RE: Capisic Pond Enhancement, Level III Site Plan Application, Response to Comments

Woodard & Curran has reviewed the comments received from the Planning Division for the Capisic Pond Enhancement Project Level III Site Plan application. The comments were received as attachments to the Planning Division Memo dated January 24, 2013, and are listed below in italics, with our responses following each comment:

**G-001**

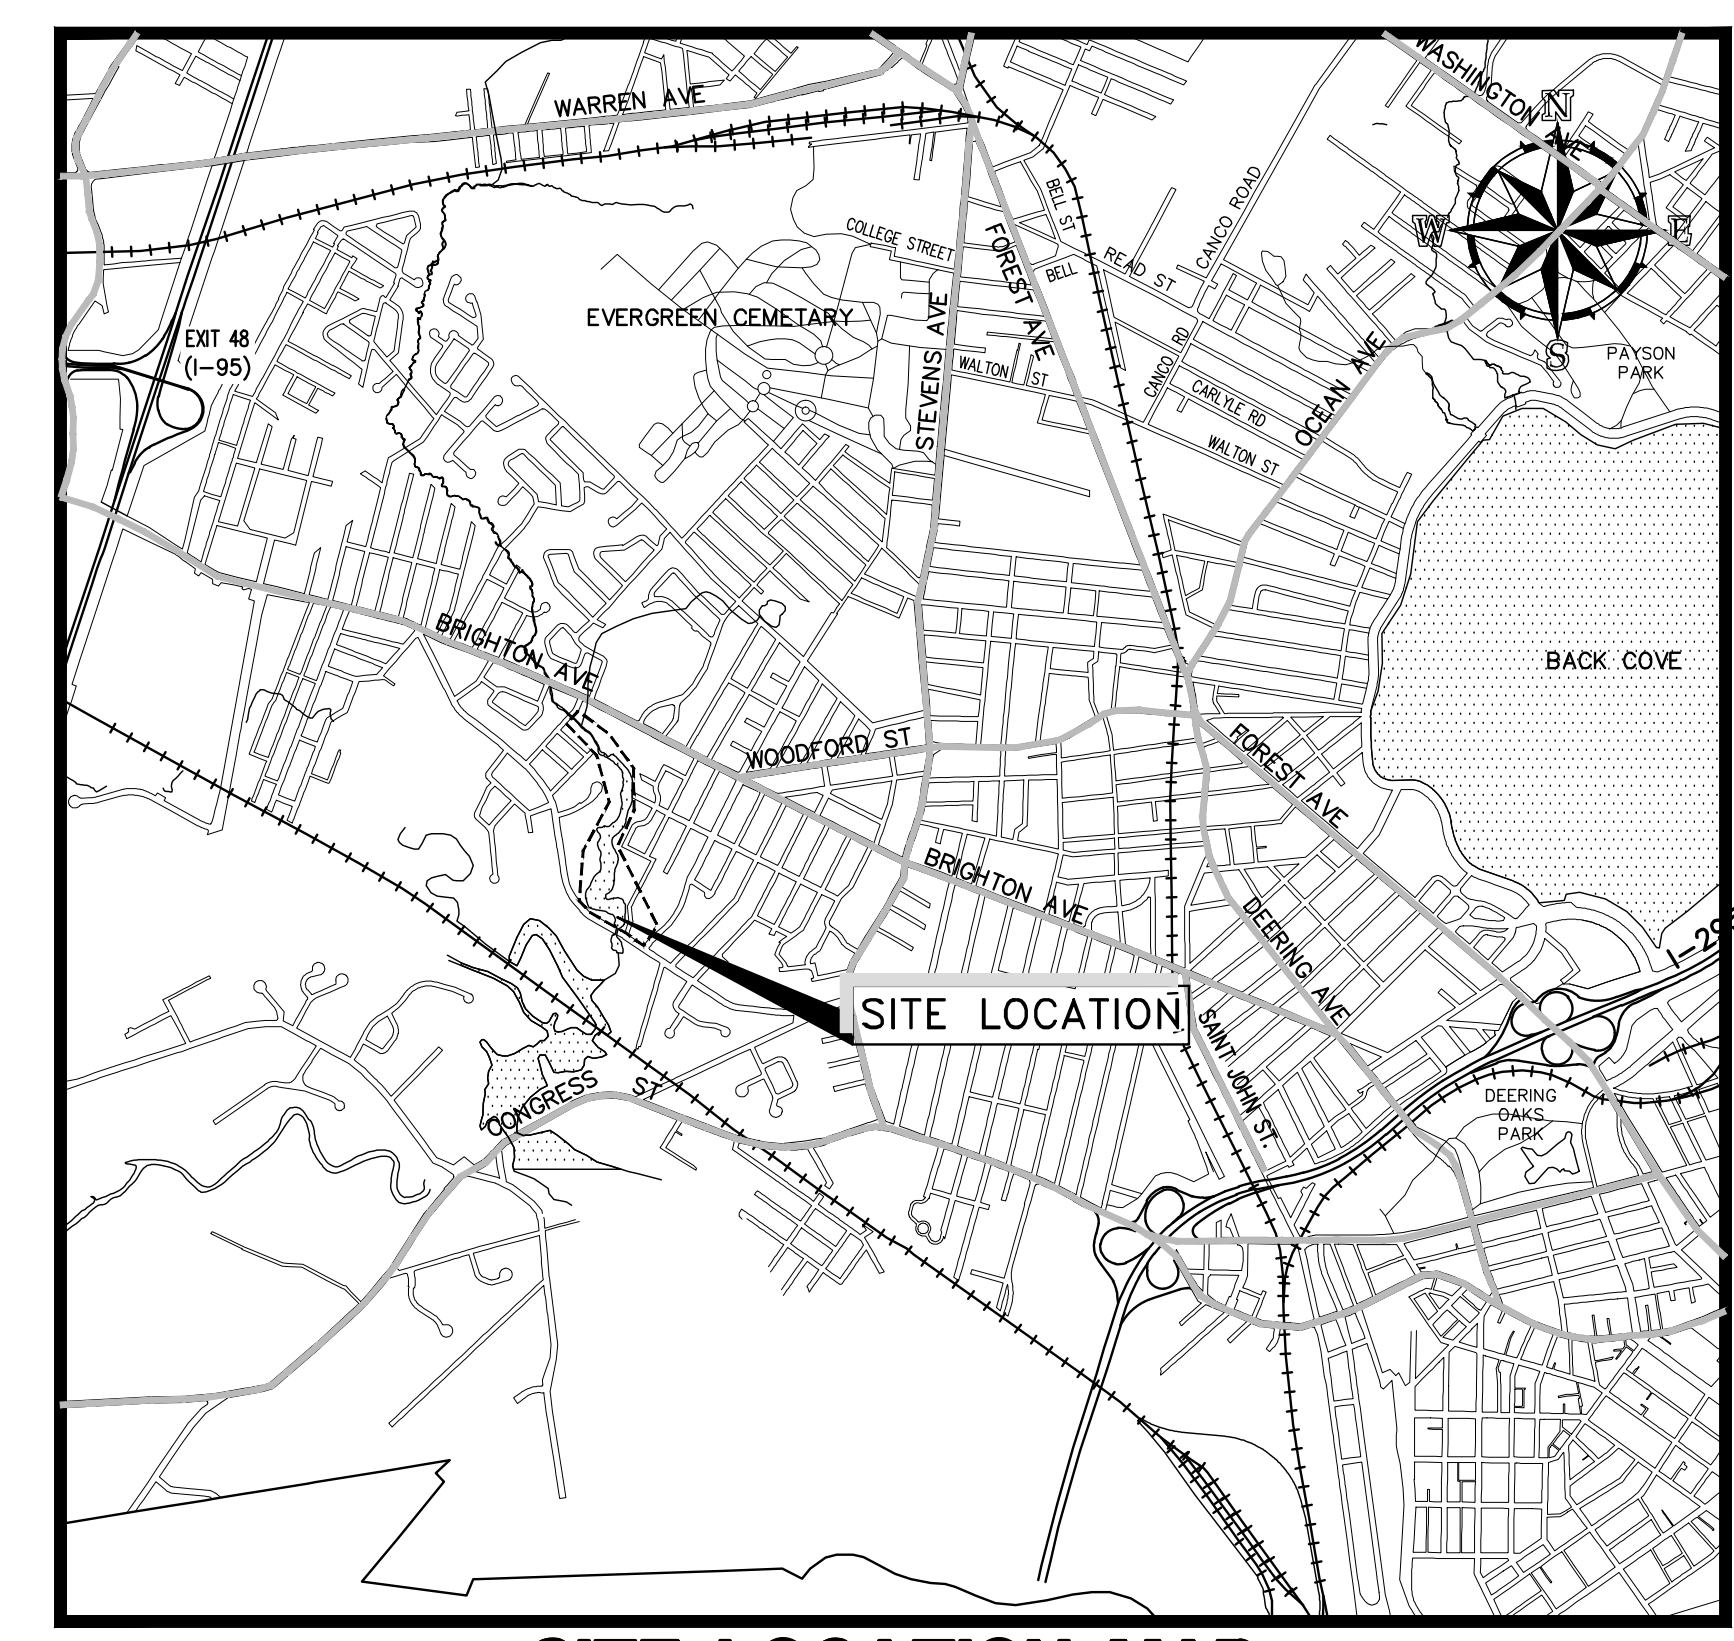
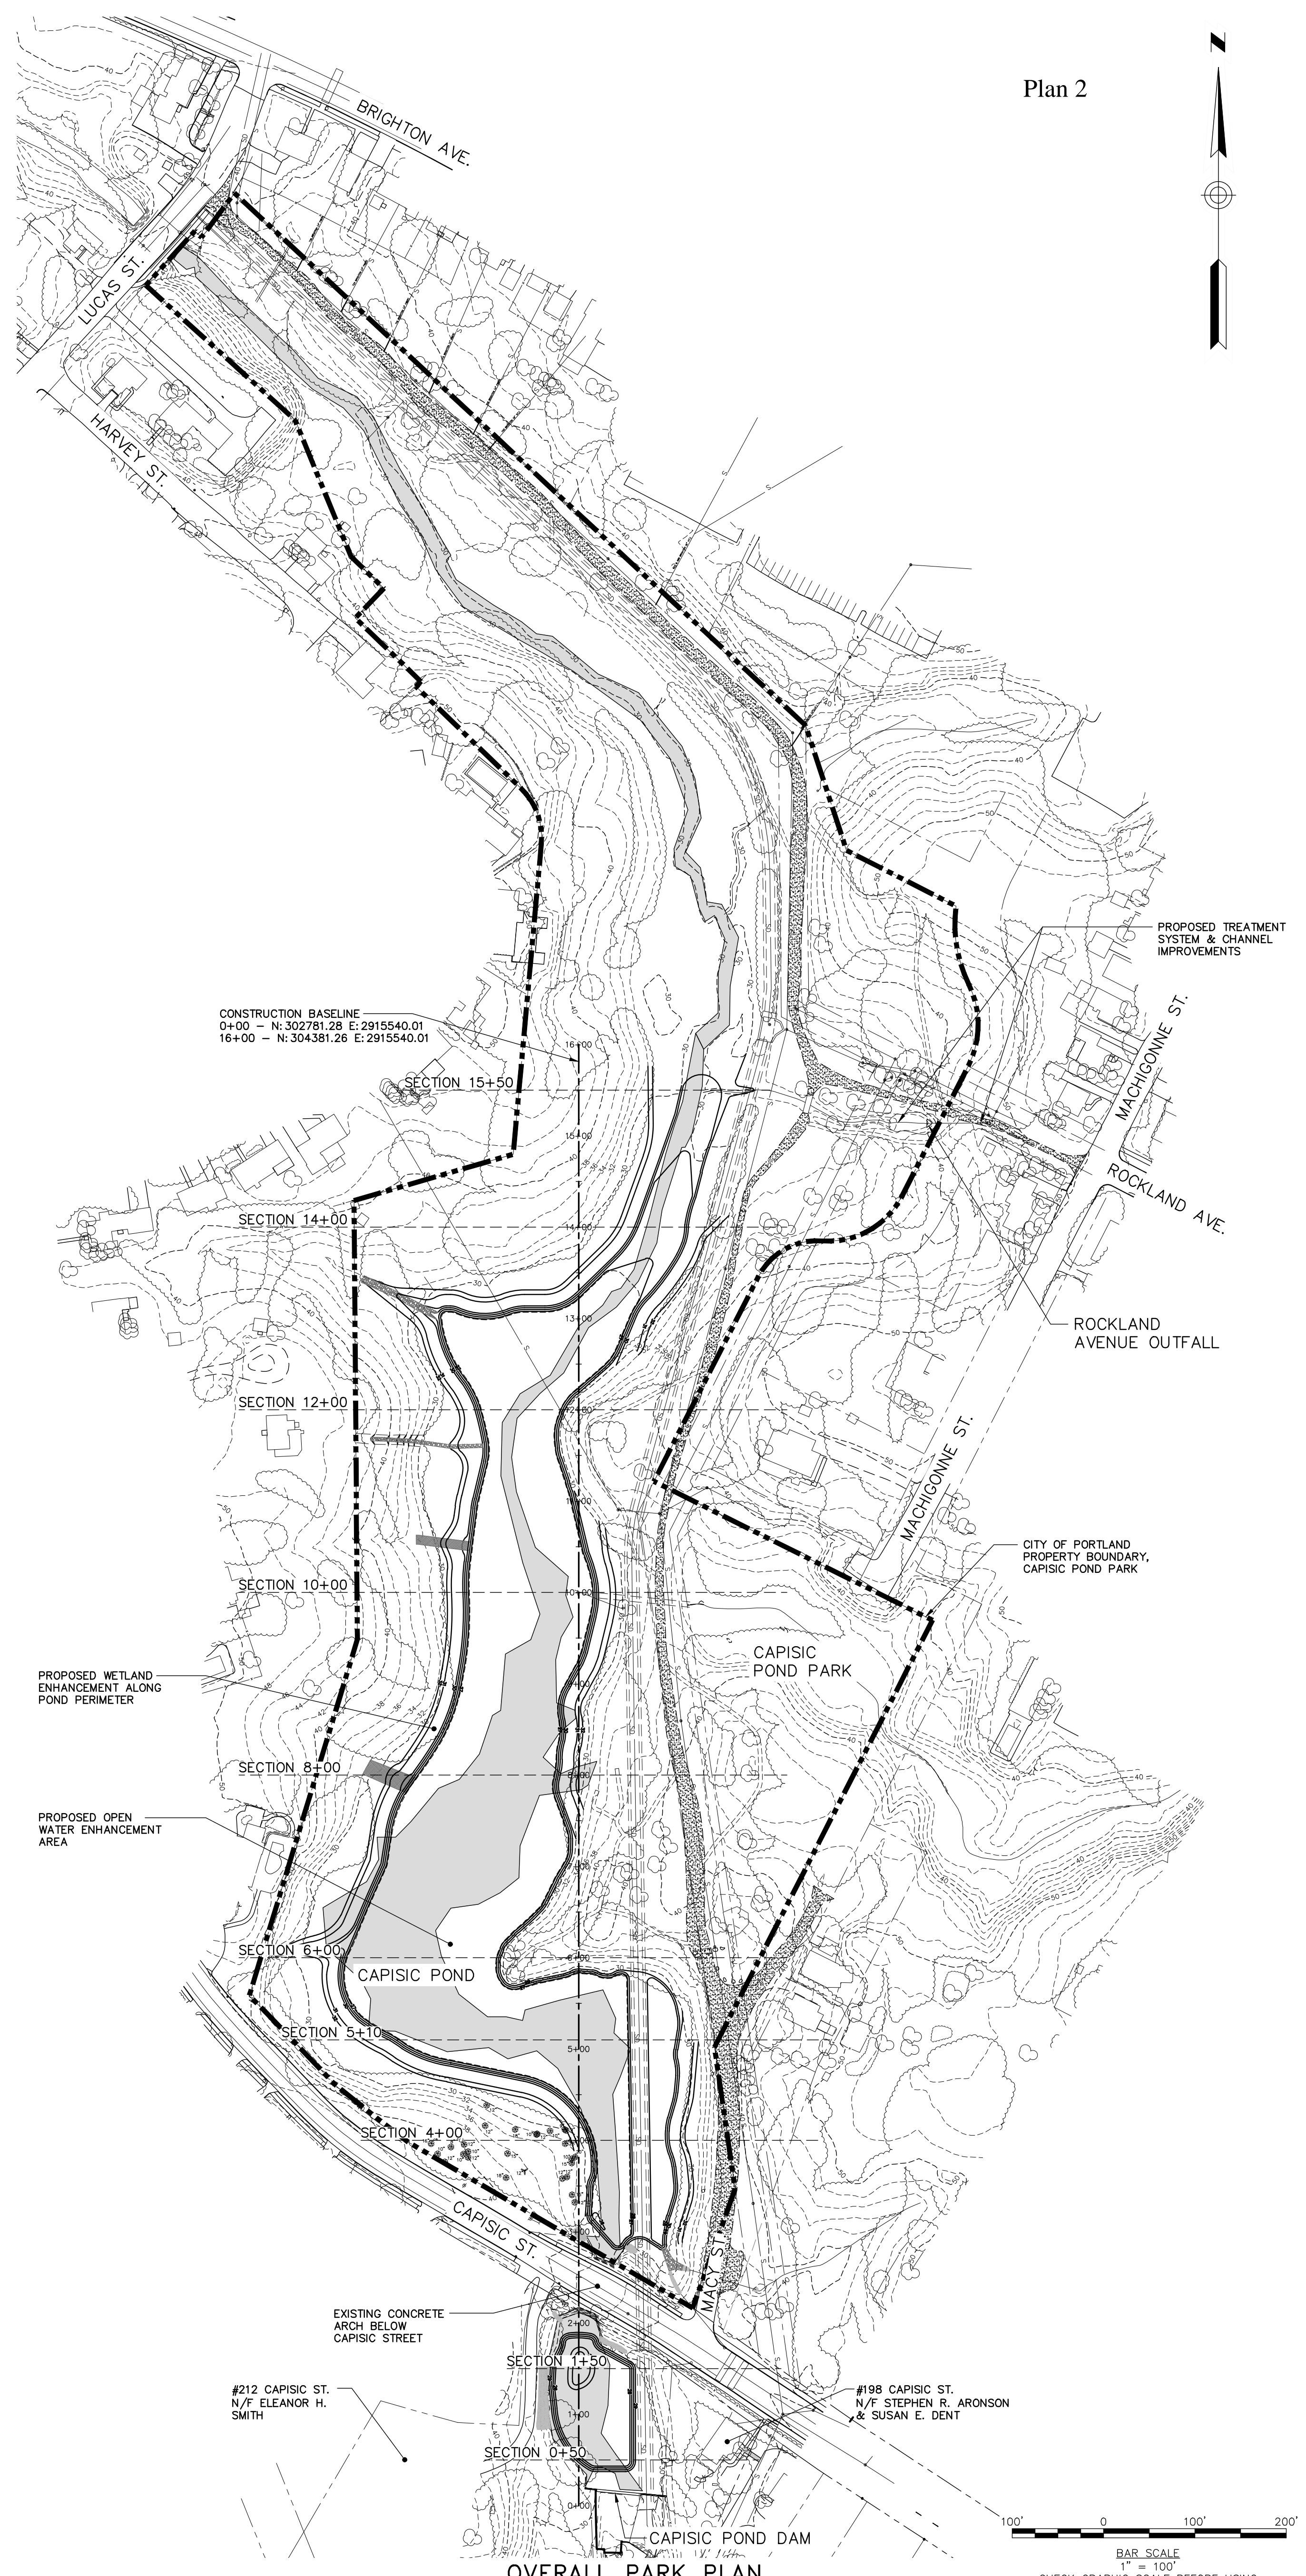
1. *Please add a note to the plans stating that 'The Contractor shall be responsible for any sweeping due to materials inadvertently falling on the roadway between the dredge and disposal site.'*

As noted in the response to the comment above from Tom Errico, the Contractor will be required to manage the cleanup of sediments tracked from the site by construction vehicles. Notes requiring sweeping have been included on the plans as part of the general notes, as well as part of the erosion control notes.
